**SSD 13137914 – Marulan Solar Farm Environmental Impact Statement – LOT 55 DP  
1141136, 740 CARRICK ROAD, CARRICK**

Transport for NSW (TfNSW) is responding to the Environmental Impact Statement (EIS) referred on 15 September 2022 via the Major Projects Portal.

TfNSW has reviewed the information and is unable to support the development's proposed access arrangements in their current form, as detailed in Appendix L (Traffic Impact Assessment) of the EIS. Details of **additional required information** is set out in **Attachment 1**.

MUNRO ROAD INTERSECTION
NTS

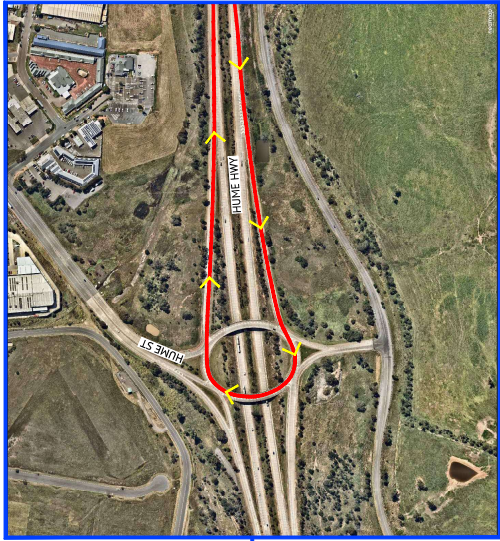
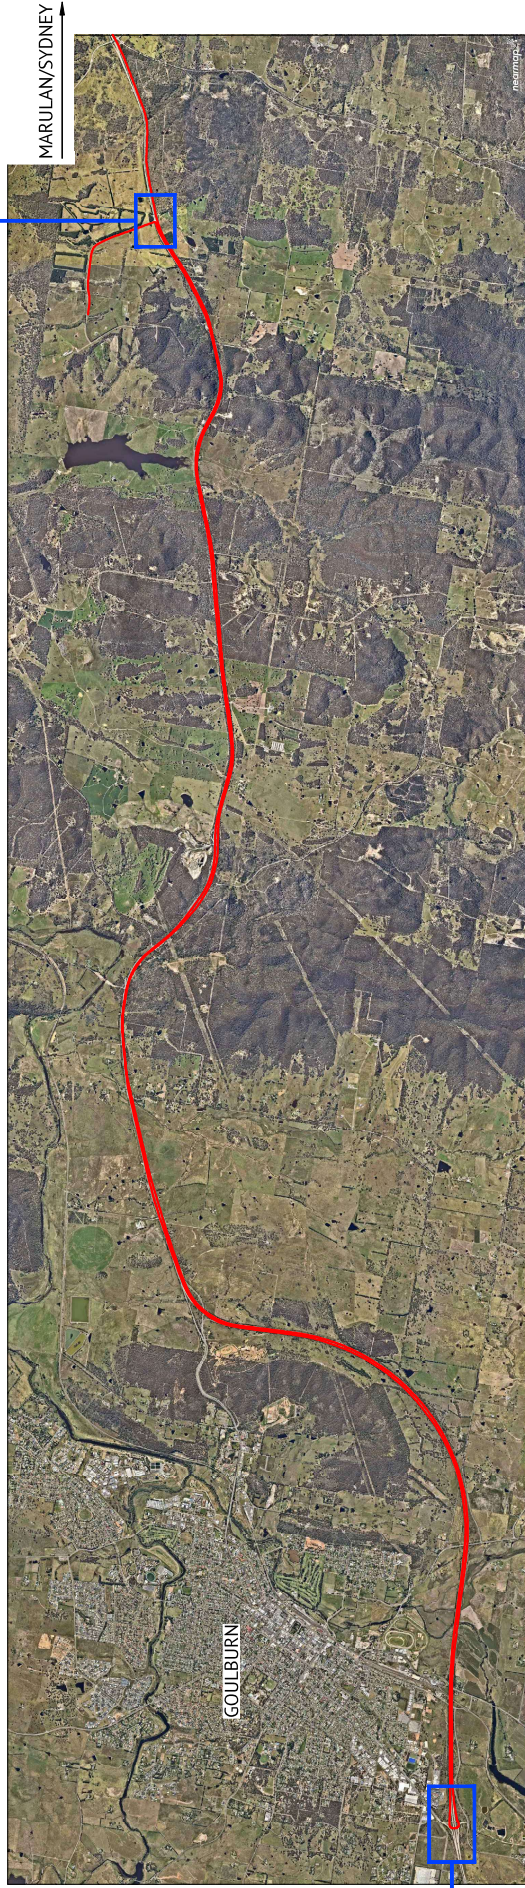
- The Traffic Impact Assessment (TIA) proposes a drivers Code of Conduct, where both heavy and light vehicle drivers to and from the site perform left in and left out manoeuvres at the Munro Road intersection. The detour route for vehicles originating from the north is approximately 50km.

- The TIA assumes that all light vehicles will originate from Goulburn and therefore utilise the existing AUL from the Hume Highway into Munro Road.
- The TIA does not provide any analysis with respect to right turn vehicles into and out of Munro Road.

- The assumption that all light vehicles will be northbound and therefore turn left into Munro Road is not practical. TfNSW do not believe that this will be the case for all light vehicles, noting that a Drivers Code of Conduct in isolation for light vehicles may be challenging to enforce. TfNSW highlight that if right turns are not permitted at this current location, light vehicles may choose the next available opportunity to perform a u-turn, which is not an acceptable outcome.
- The traffic analysis does not incorporate any analysis of right turn vehicles into and out of Munro Road at the Hume Highway. TfNSW highlight that right turns into and out of Munro Road are currently permitted.
